17 August 2018

## Re: Eden Breakwater Wharf MOD 1 - Response to Submissions – Air Quality and Noise

Figure 3-1: Cumulative frequency distribution of estimated hoteling demand with comparison to EIS modelling

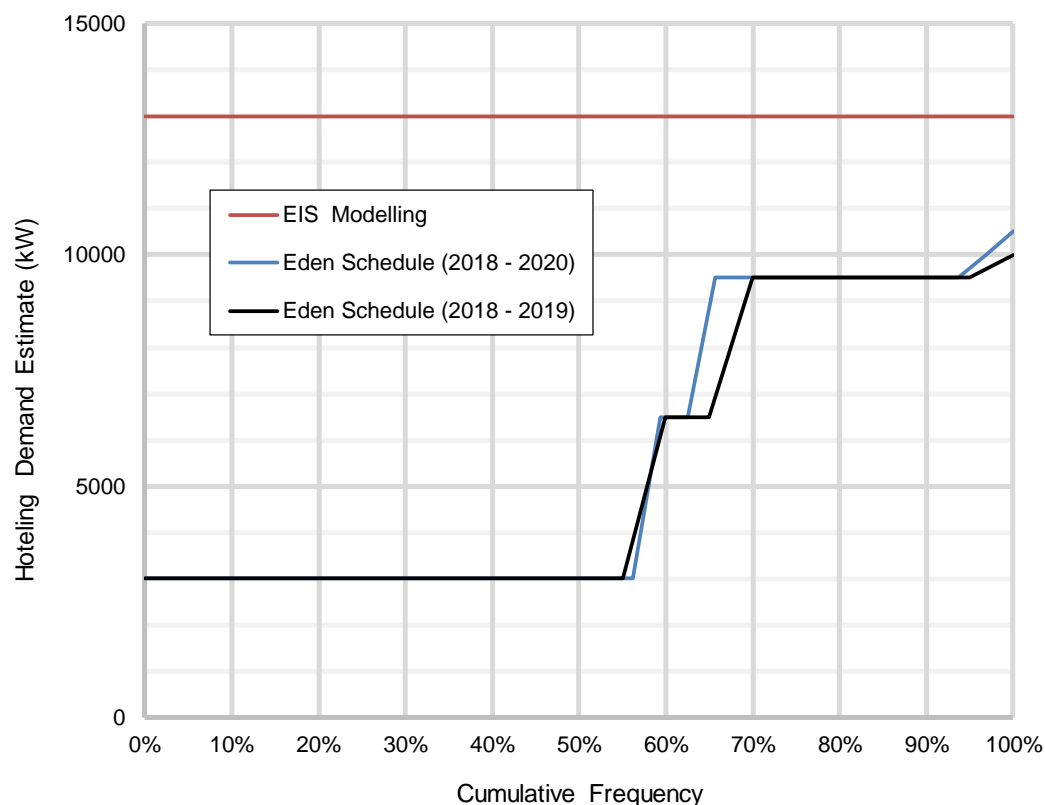
**Re Figure 3-1 in ERM air quality report. Please provide more explanation on what this graph represents. Is this the percentage of days throughout the cruise season that cruise ships are berthed compared to the EIS assumptions that a cruise ship would be berthed every day during the cruise season?**

Figure 3-1 shows a cumulative frequency distribution of estimated hoteling demand (in kW), as based on the 2018/2019 fleet mix (which forms the basis for both Typical Operations and Expanded Operations modelling). This therefore shows the assumptions made around the kW rating of the ships in berth for the purposes of the modification emissions inventory, compared to the EIS modelling hoteling demand value. Essentially, this shows that the kW rating of anticipated fleet mix falls well below the default assumption made within the EIS that all ships are rated at 13,000 kW.
